From: Andrew <andrew@o-l-ltd.co.uk>
Sent: 24 August 2019 15:31
To: _planningadvice
Cc: James Sims; john.hemingway@arcosconsultancy.com; Ronnie; Andy Richardson; mark@srcltd.com
Subject: Proposed Pack-house extension and relocation of staff parking (A1342)
Attachments: 329316_A3_Wastewater.pdf; 329316_A3_Clean Water.pdf; Anglian Water Comments.pdf

SHDC Ref: H14-0673-19

AW Site Reference:	149995/1/0064670
Local Planning Authority:	South Holland District
Site:	J O SIMS LTD PUDDING LANE PINCHBECK SPALDING PE11 3TJ
Proposal:	Proposed pack-house extension and relocation of staff parking
Planning application:	H14-0673-19

Wastewater Plan A3

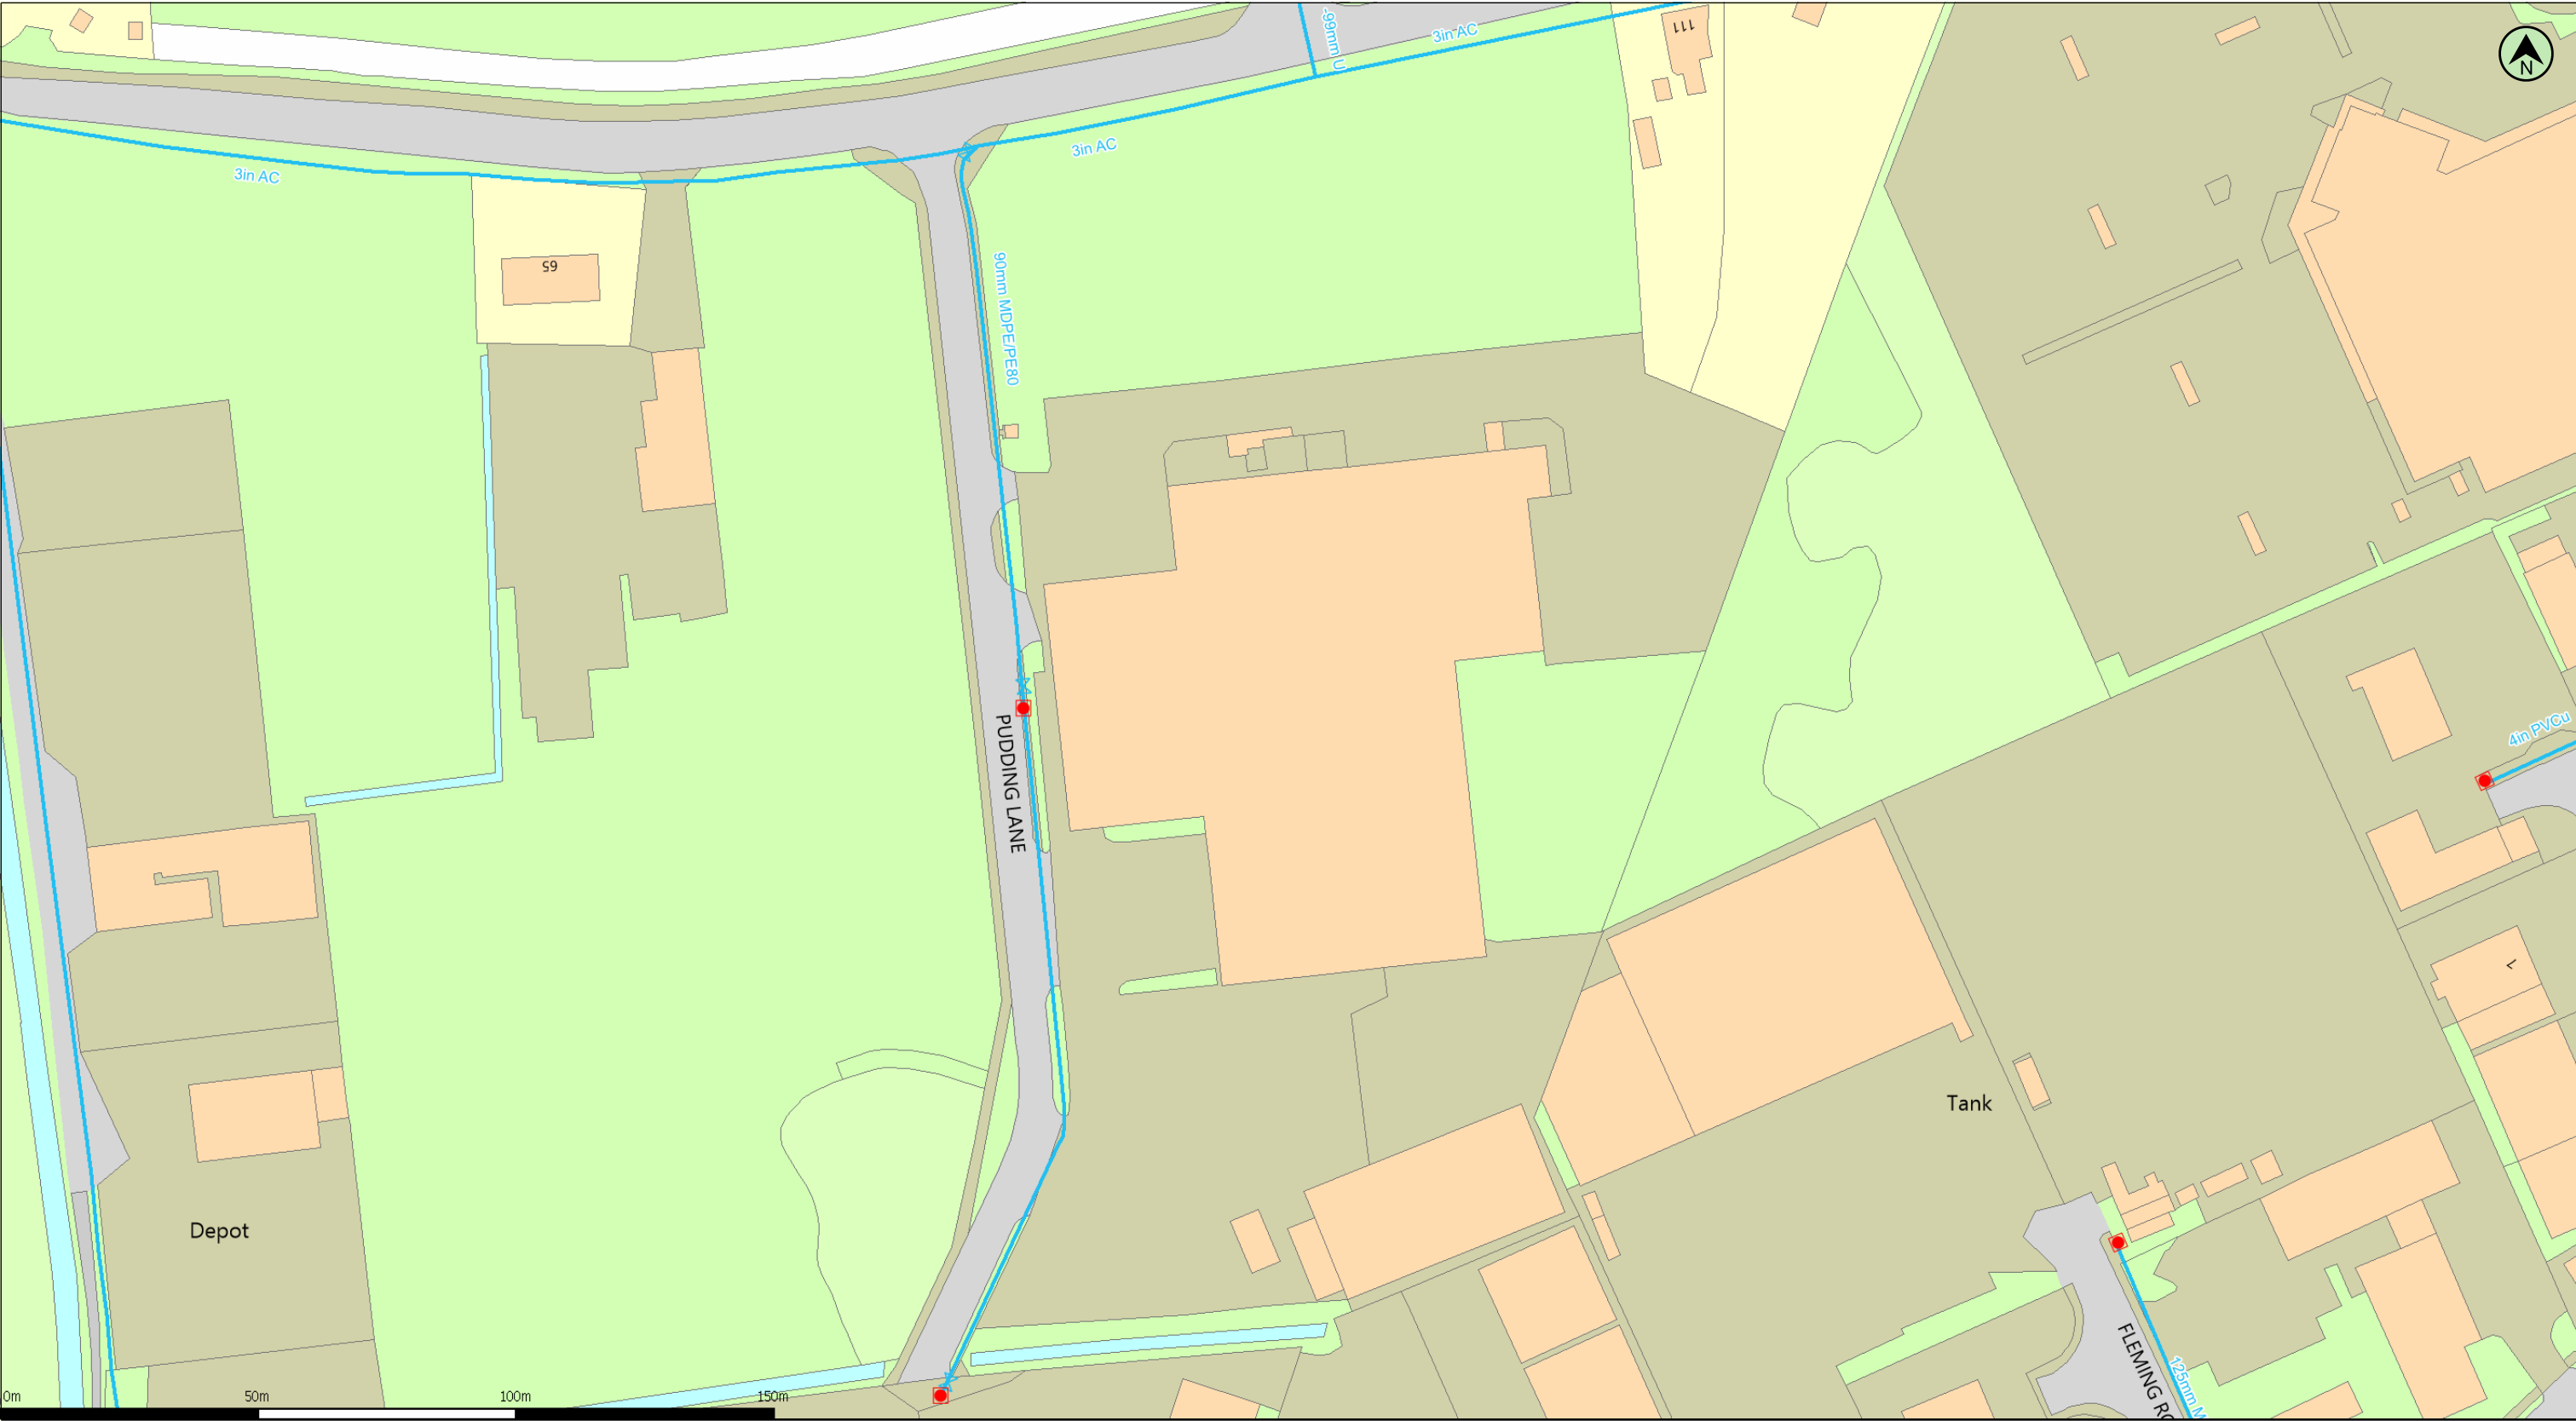
The clean water main is shown located within the edge of Pudding Lane running along the west edge of that part of the J O Sims site that is on the east side of the road. The current proposals are contained entirely within the applicant's site boundary and do not encroach upon either the road or the footpath. No built development is proposed close to this boundary. The only relevant development is the relocated car park which is of simple gravel finish. The applicant therefore does not believe that this will impact upon the clean water supply route.

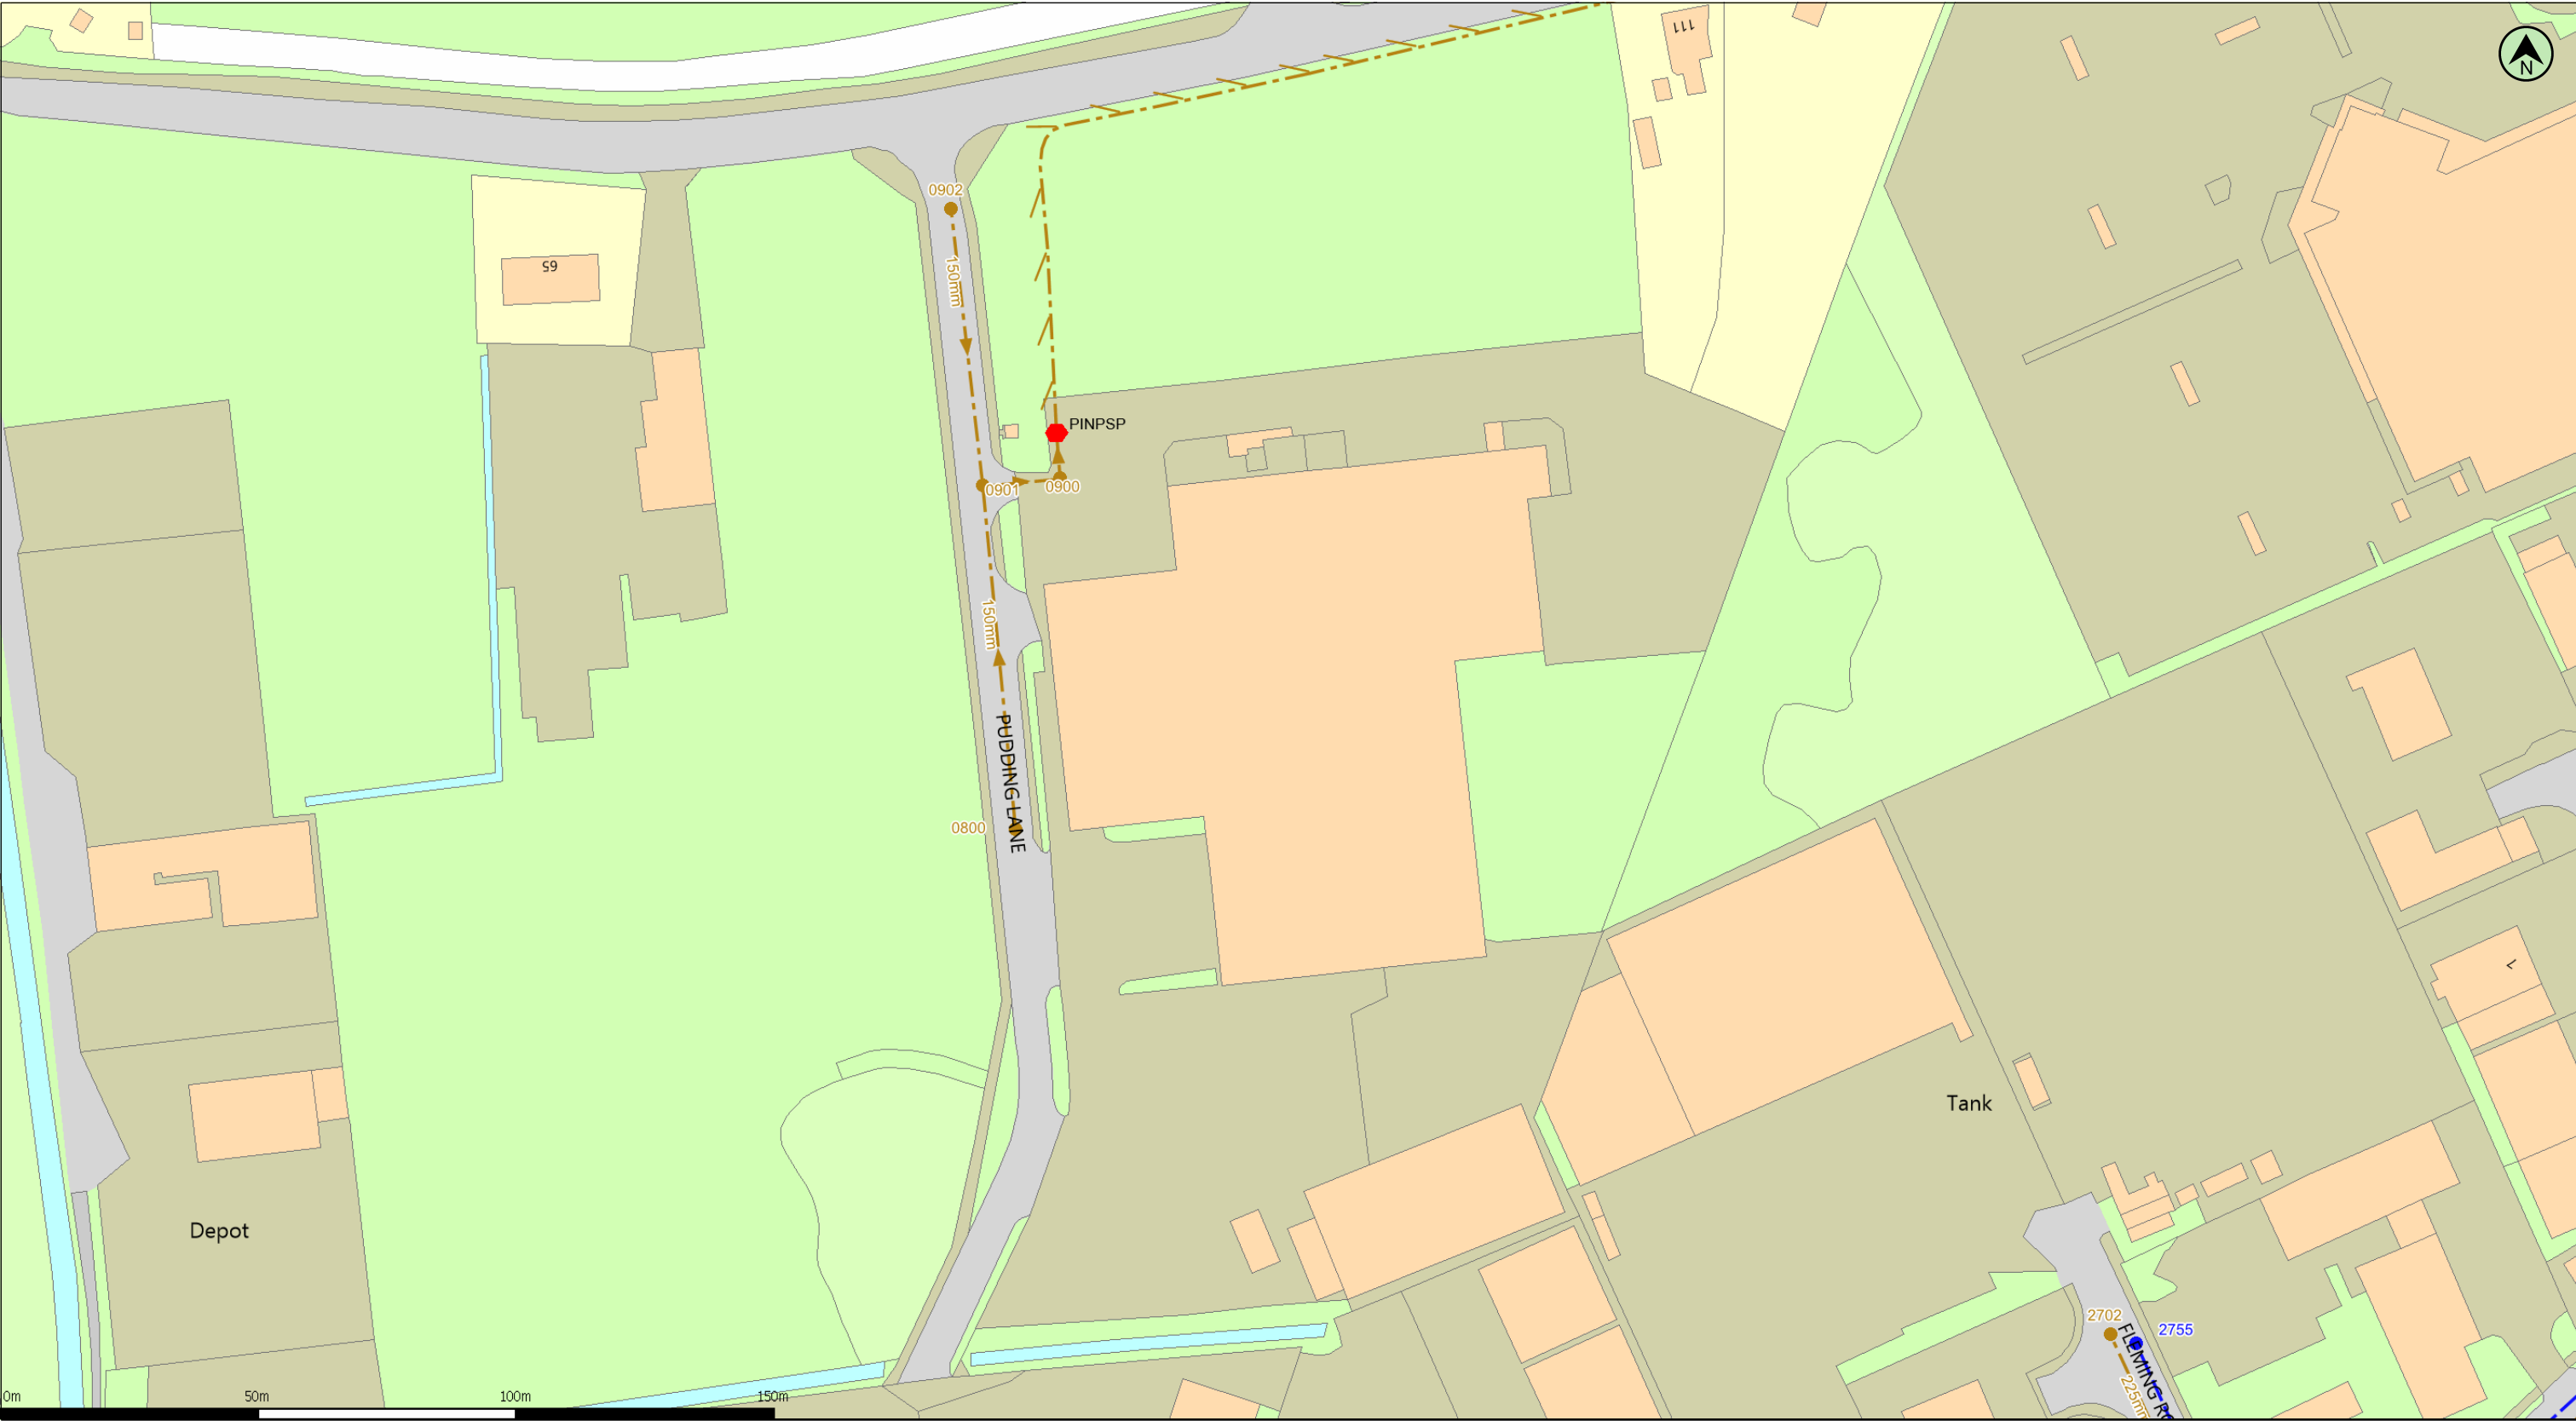
A foul water main is shown within Pudding Lane and enters the application site at its vehicular access point direct from the road. The plan shows a public pumping station within the car park area of the applicant's site from which a pumped rising main appears to head north before turning east along the south edge of Wardentree Lane. The pumping station covers have been identified on site (they are locked and are therefore inaccessible except presumably by Anglian Water's own operatives). The rising main must already run beneath the car park but only along the very edge nearest Pudding Lane. The proposed building works (pack-house extension) are remote from this and will therefore have no impact. The works to relocate car park B as an extension of car park A are closer to the pumping station but no closer than the existing access area / car park in which it already stands. Whilst the car park is being extended northward it is not believed that this will be of significant detriment to the rising main since the finish to the new car park area simply replicates what is already there. The main appears to skirt the west edge of the site against the very west edge of the car park. The applicant does not therefore believe that the works will impact upon the main or pumping station. The correspondence relates to dwellings within 15m of the apparatus however our proposal does not involve buildings of any type within 15m, so this does not appear entirely relevant.

The development site is within 15 metres of a sewage pumping station. This asset requires access for maintenance and will have sewerage infrastructure leading to it. For practical reasons therefore it cannot be easily relocated.

The site layout should take this into account and accommodate this infrastructure type through a necessary cordon sanitaire, through public space or highway infrastructure to ensure that no development within 15 metres from the boundary of a sewage pumping station if the development is potentially sensitive to noise or other disturbance or to ensure future amenity issues are not created.
